BEACON FEN ENERGY PARK

PROPOSED BEACON FEN ENERGY PARK (APPLICATION REFERENCE: EN010151)

REQUEST FOR PROPOSED CHANGE TO THE DCO APPLICATION ('CHANGE REQUEST')

Figure 6.32 Vegetation Removal Plan Part 1 (Change Request)

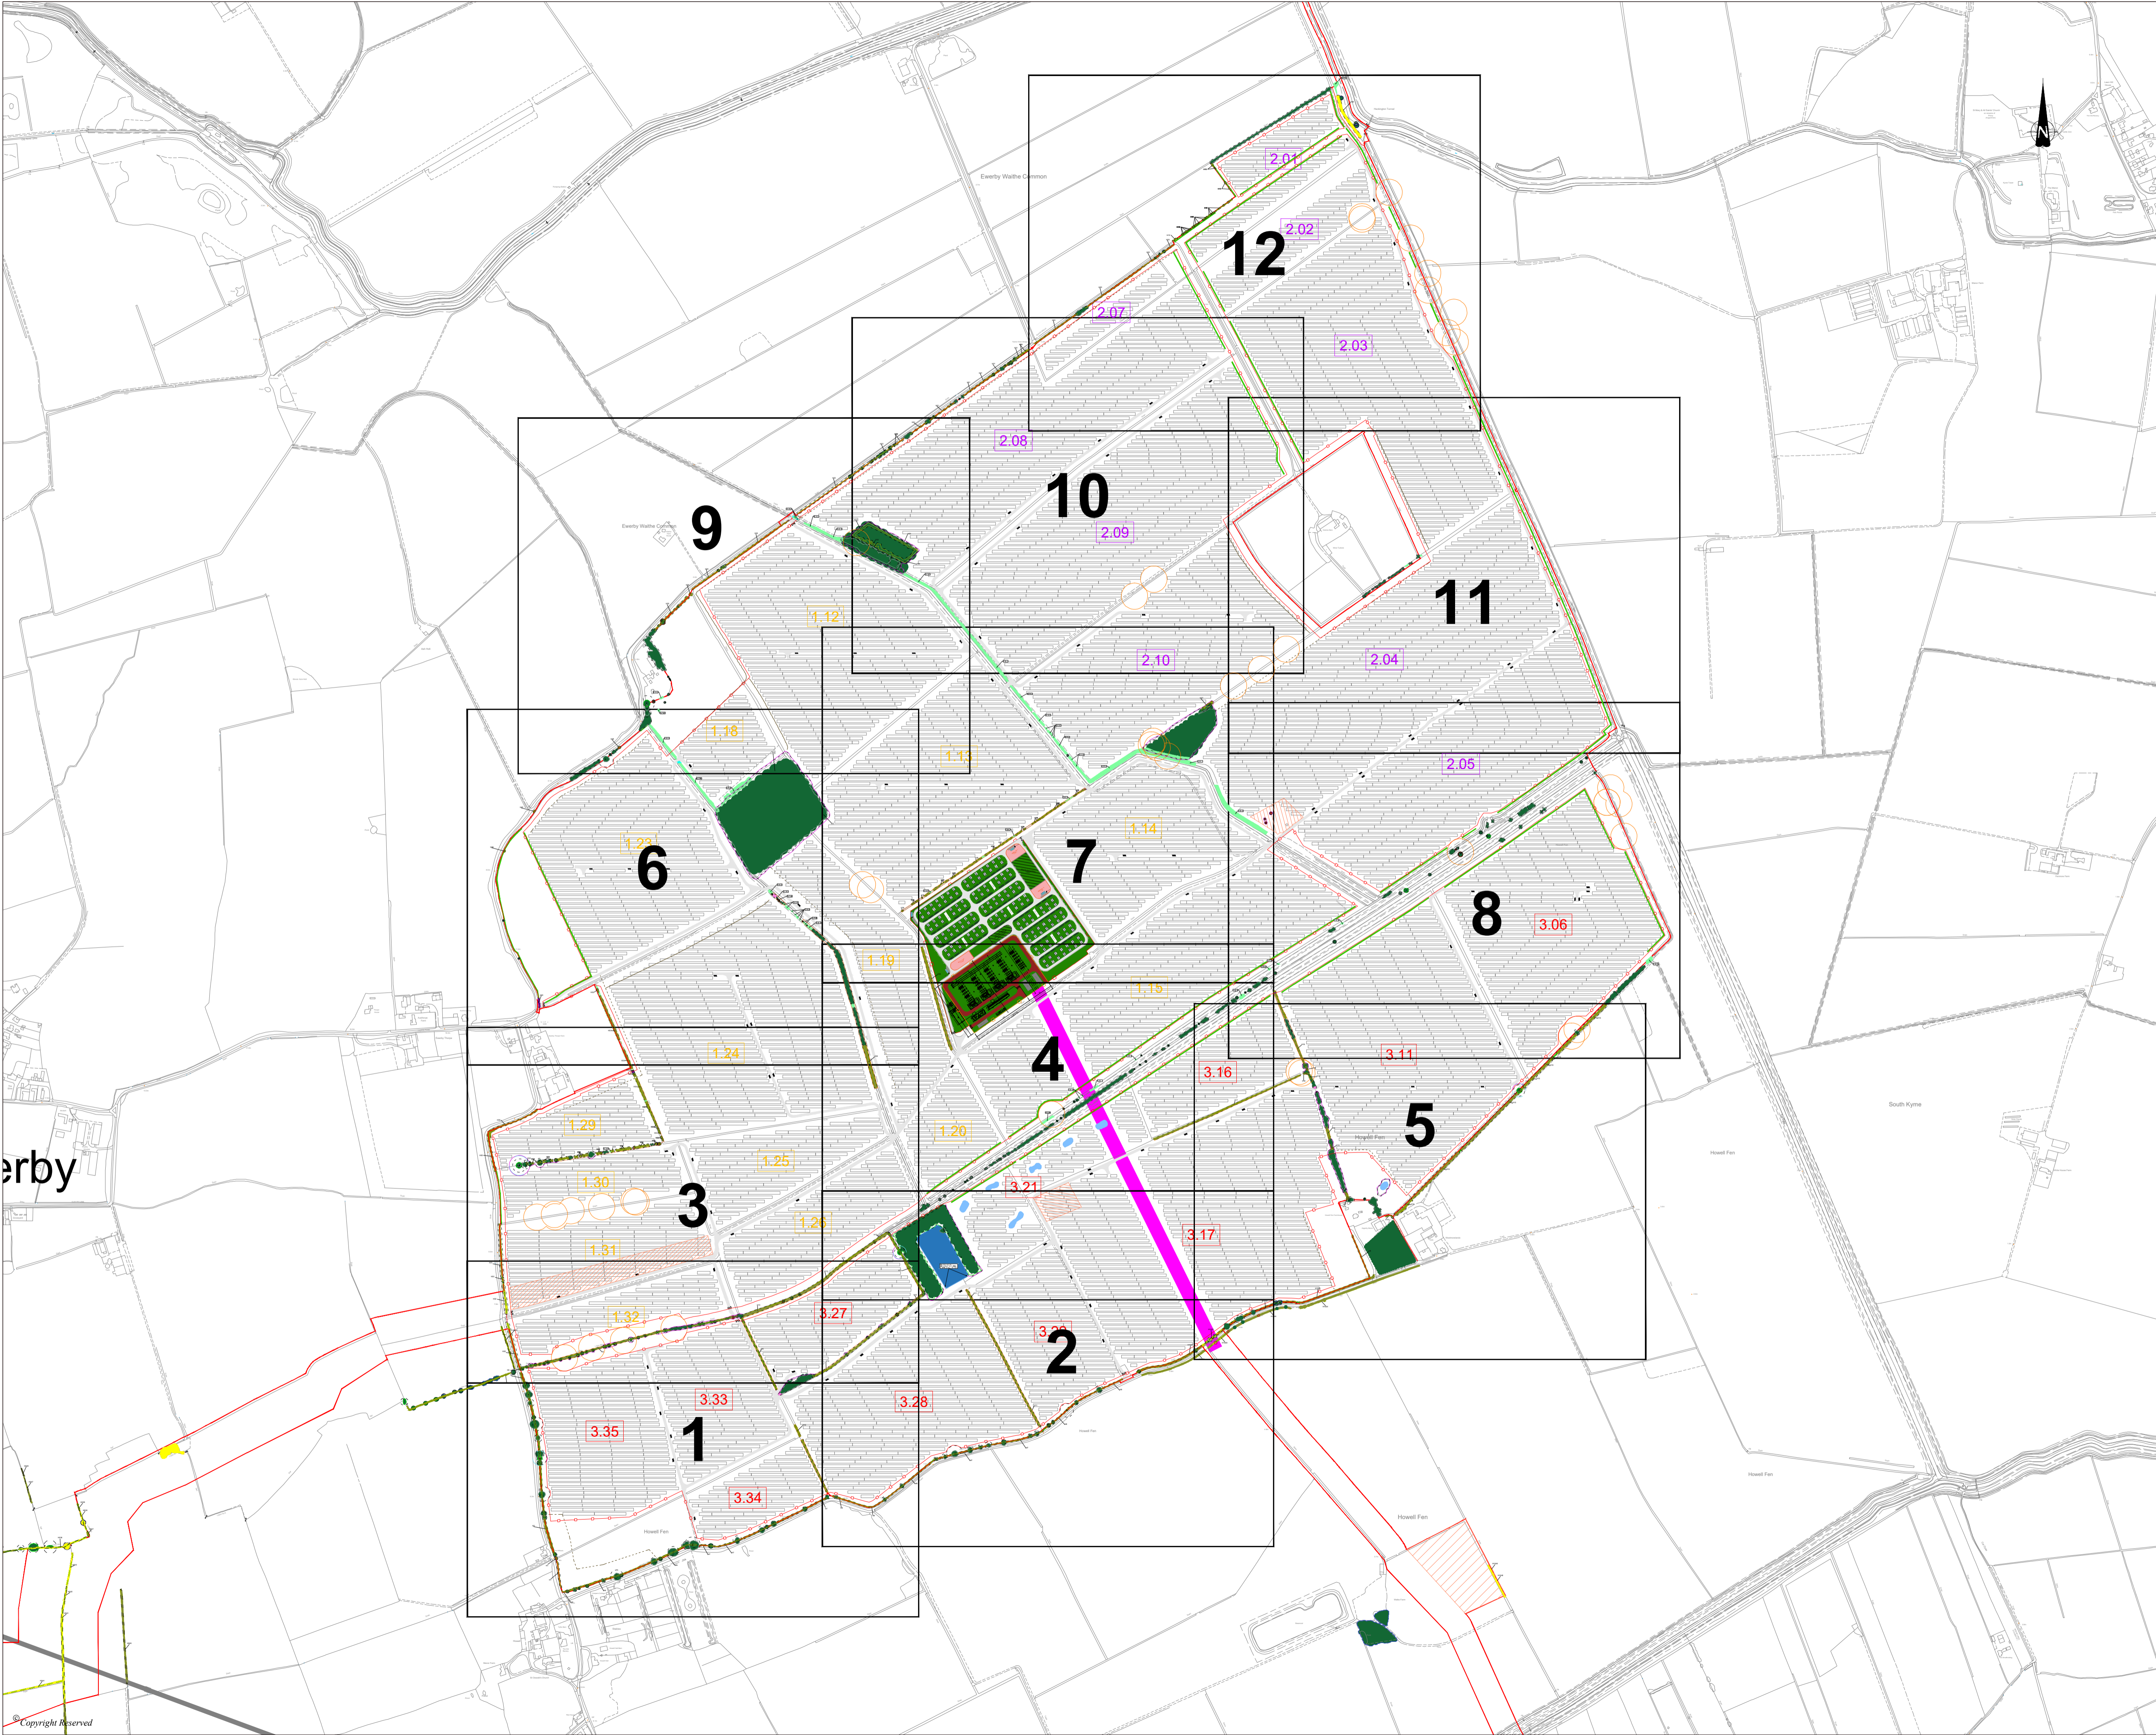
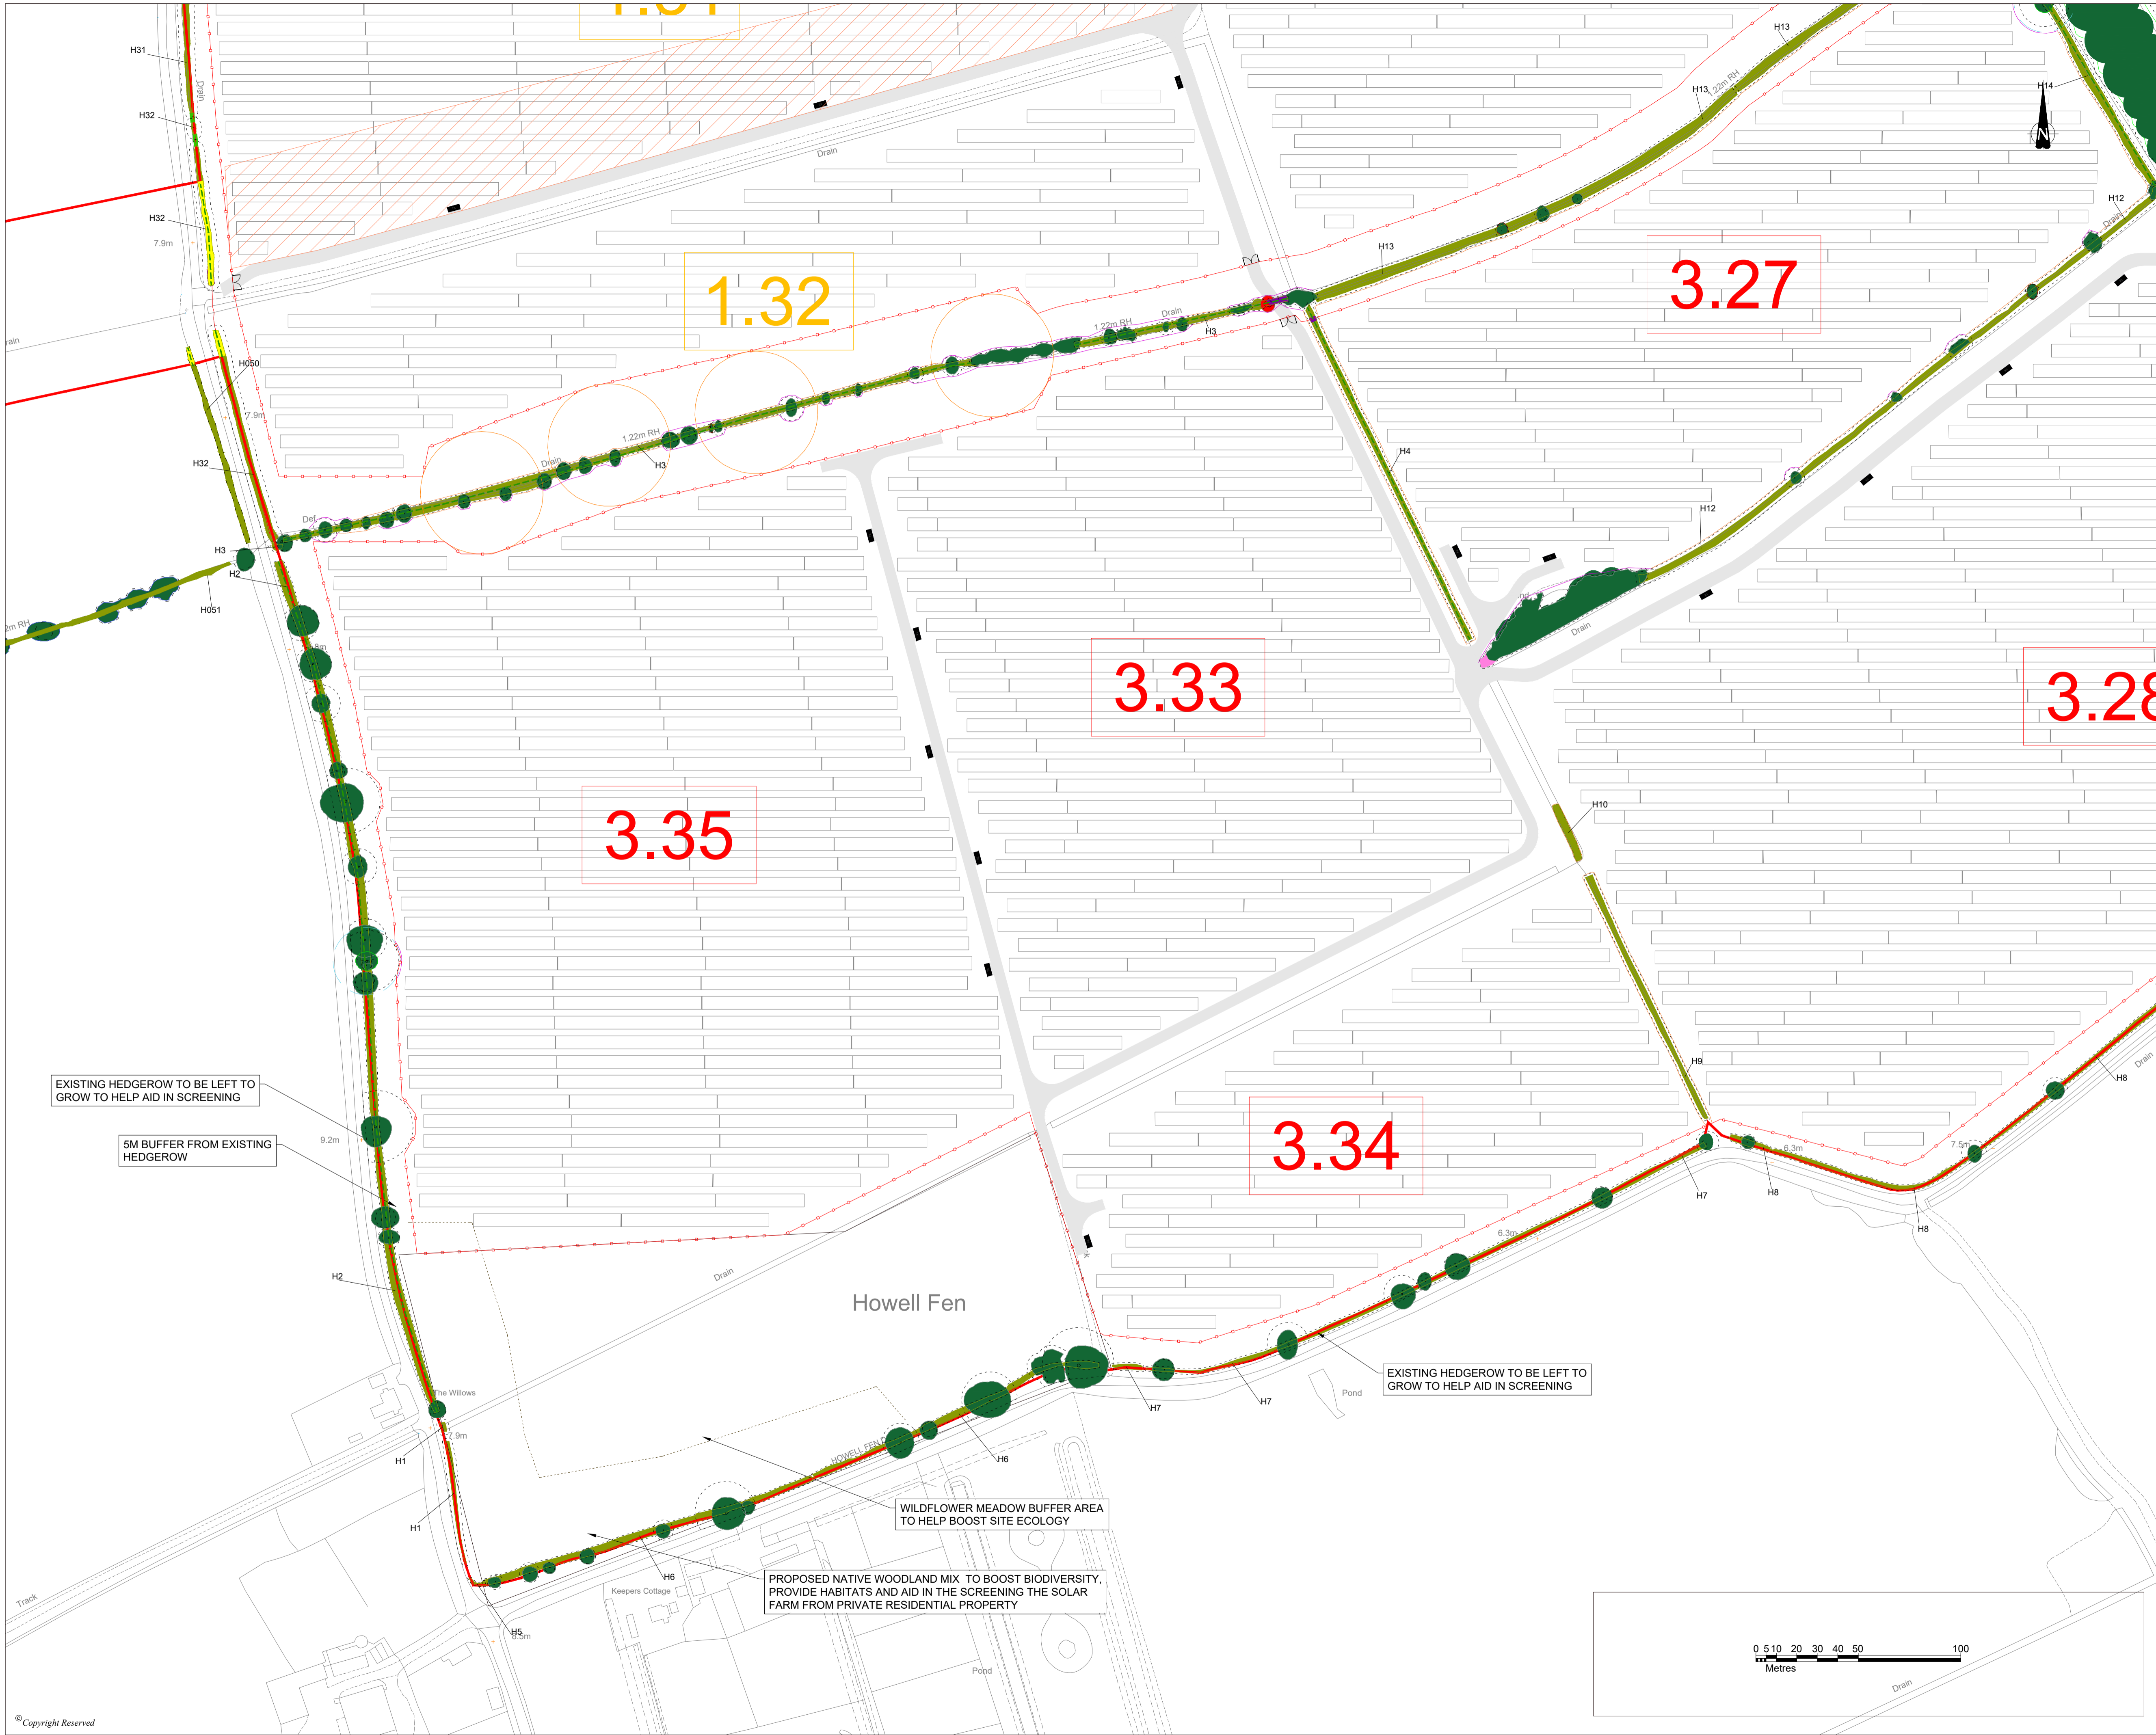
- Extension of the temporary laydown (Work No. 5D) to an area that is largely existing hardstanding adjacent to the south; and
- Vegetation removal and infilling of the existing drainage pond adjacent the Substation to construct the Substation extension works (Work No. 5E);
